Planning Application Technical Response

Site:	57 Queensway, Bognor Regis
LPA Reference:	BR/67/25/PL
Date Assessed:	20 May 2025

FULL APPLICATION	Related Policy or Standard	Applicant Action Required	LLFA Specific Comment
All sources of flooding considered?	NPPF Paragraph 165, 173 PPG Paragraph 051 SDNSTS S10	Provide updated information within an amended FRA on;	
		<input type="checkbox"/> Fluvial flooding from the ordinary watercourse	
		<input checked="" type="checkbox"/> Surface water flow path originating offsite	Objection- please provide
		<input type="checkbox"/> Groundwater flooding	
		<input checked="" type="checkbox"/> Rainwater surcharged sewer flooding	Objection- please provide
		<input type="checkbox"/> Historic flood information	Objection- please provide. Southern Water Records checked?
Mitigation not appropriate	NPPF Paragraph 165, 173 and 180 PPG Paragraph 004, 023, 037, 041, 042, 043 and 044	<input type="checkbox"/> Use sequential approach with the following hierarchy. <ol style="list-style-type: none"> I. how can the development first avoid the risk of flooding II. how will it be mitigated (with evidence) III. how will flood resistance and resilience be employed 	N/

Client:  
Project:  
57 Queensway, Bognor Regis, PO21 1QW  
Drawing:  
Proposed Drainage Strategy

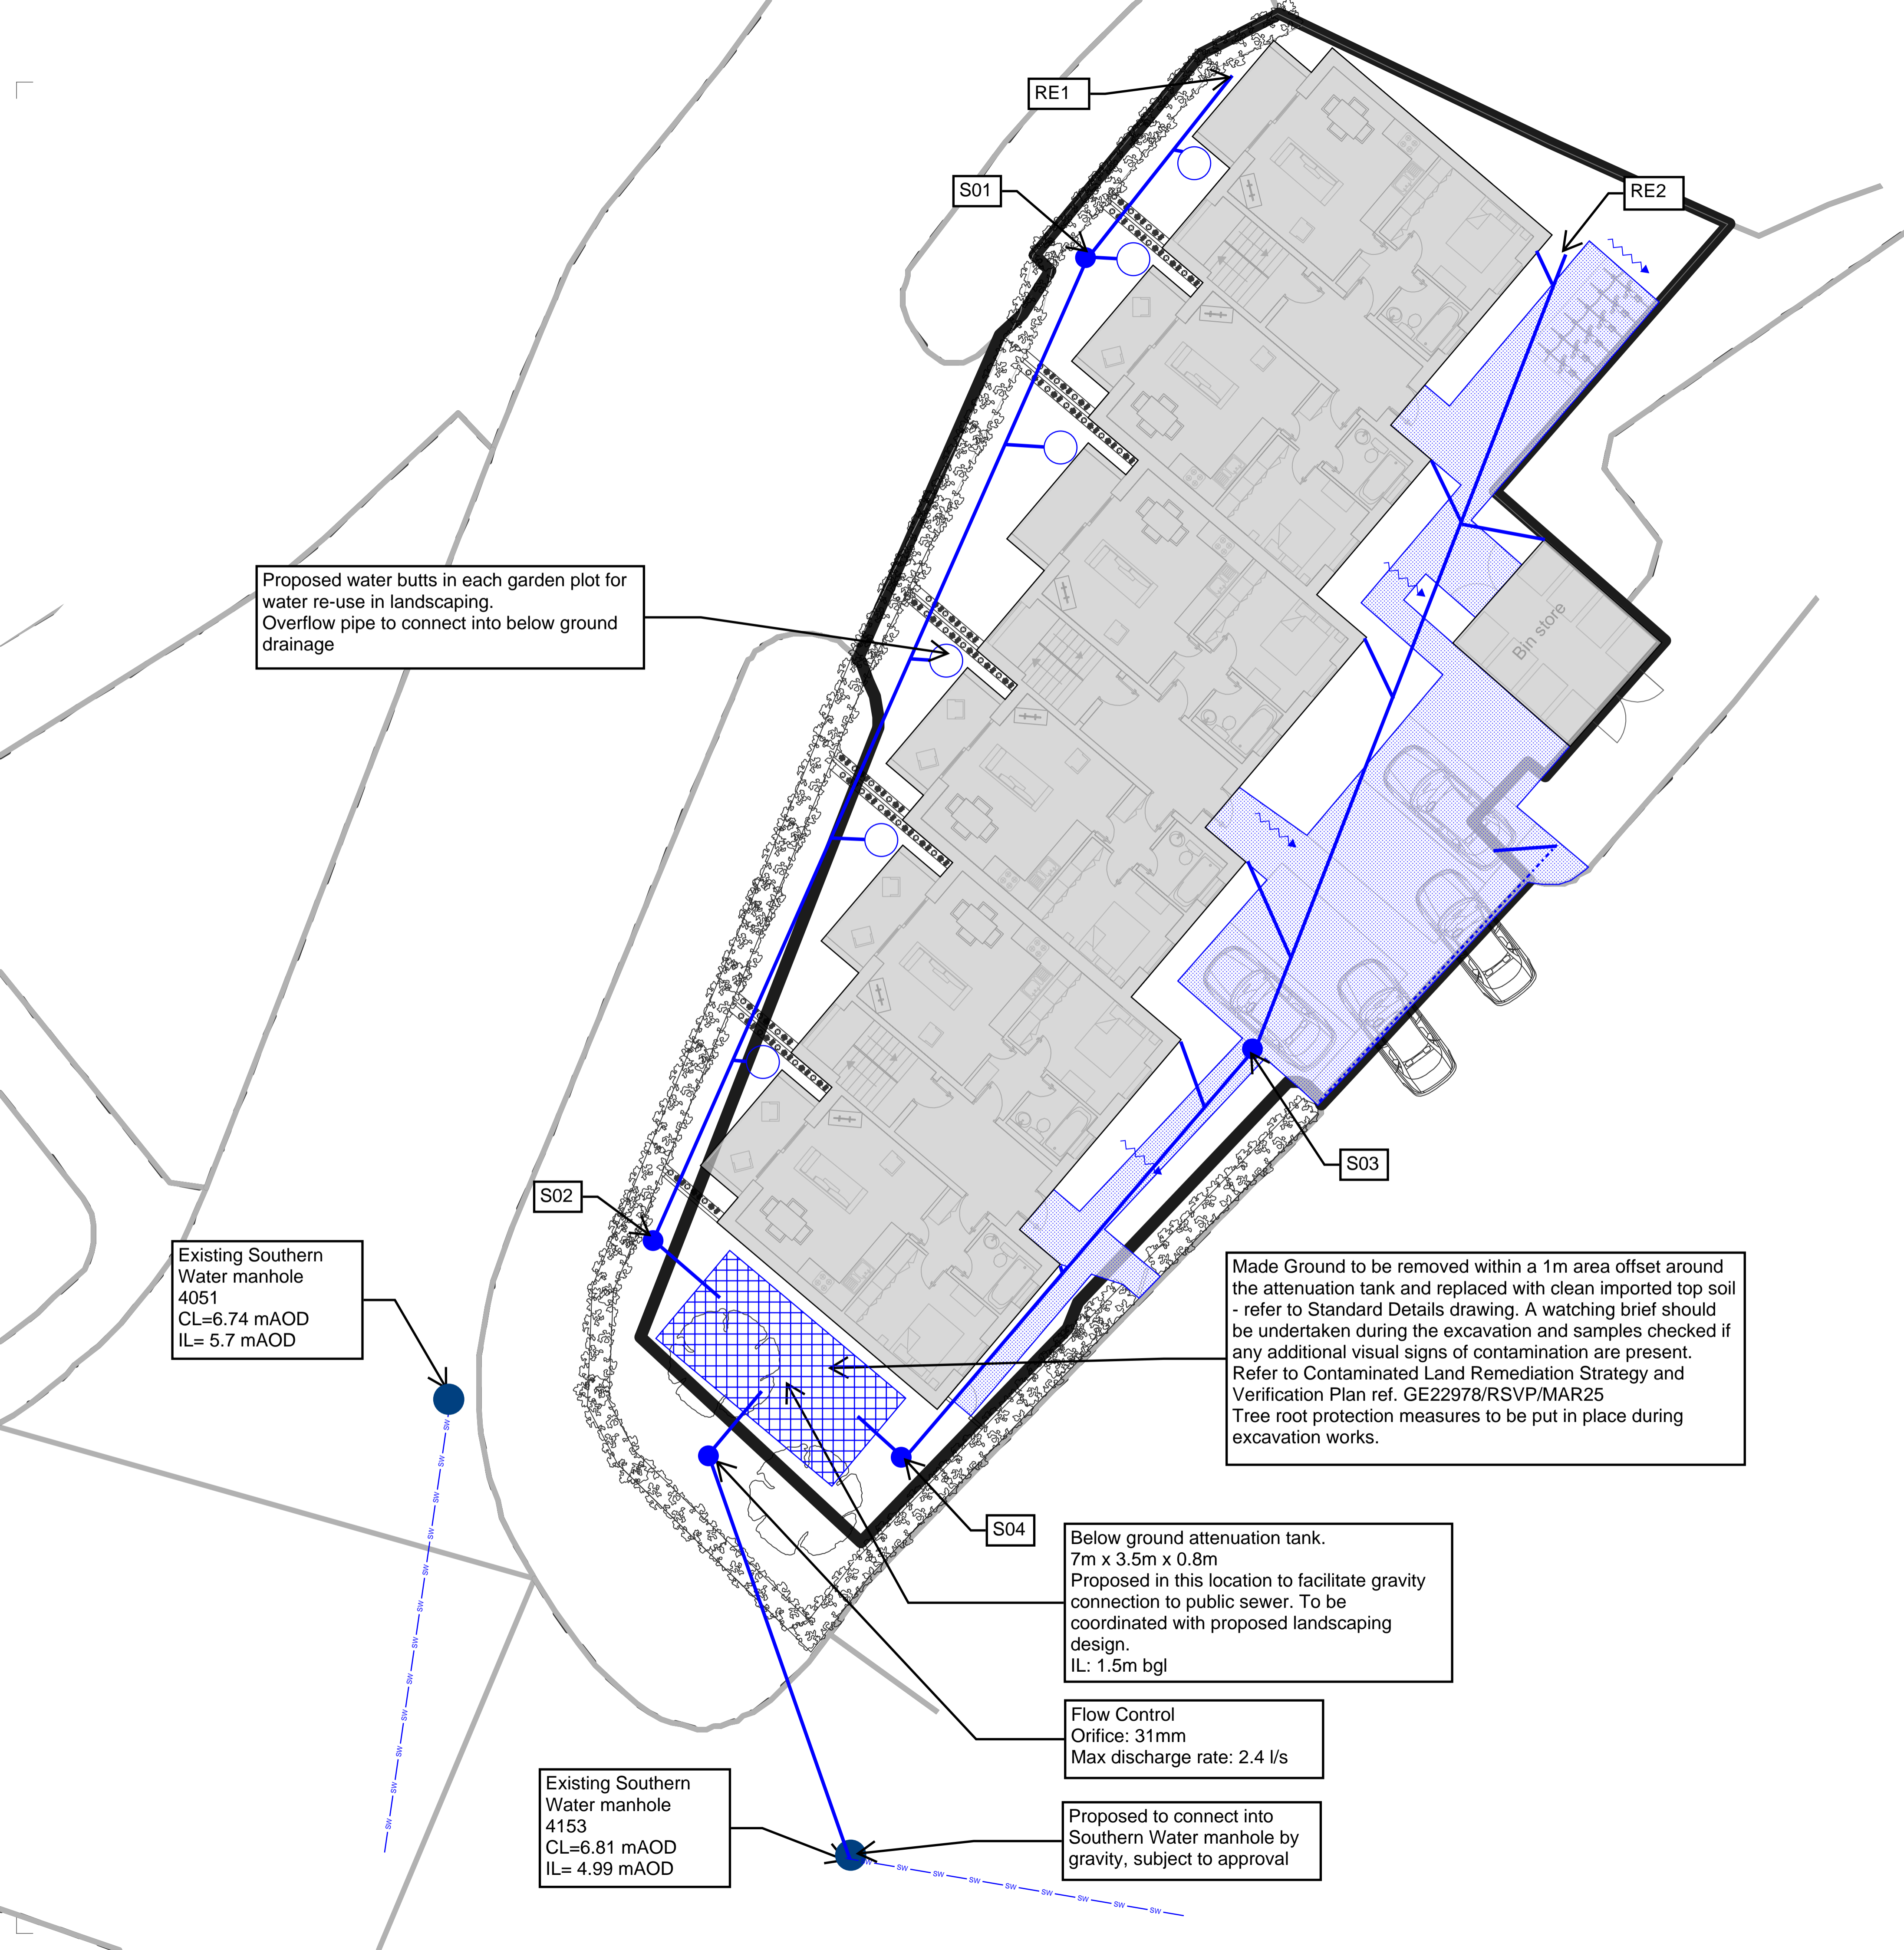
<input checked="" type="checkbox"/> Use up to date FEH2022 rainfall parameters in any modelling scenarios.	Objection- please provide
Location of SuDS		<input checked="" type="checkbox"/> Masterplan drawings need to show the high-level location of all SuDS and demonstrate that the volume of storage can be achieved in the layout.	Objection- please provide
How will the drainage and watercourse features be managed and maintained?	NPPF Paragraph 175 PPG Paragraph 055, 057 and 058 SDNSTS S10, S11, S12, S13 and S14	<input checked="" type="checkbox"/> Details of required maintenance of any SuDS features and structures and who will be adopting these features for the lifetime of the development.	Objection- please provide
		<input type="checkbox"/> Appropriate easements (to the adopting authority standard) to SuDS features should be shown on a drawing, this will be a minimum of 3m.	N/A
		<input type="checkbox"/> Indicative vehicular access route and off-road parking needs to be provided to ponds, basins and swales within the masterplan.	N/A
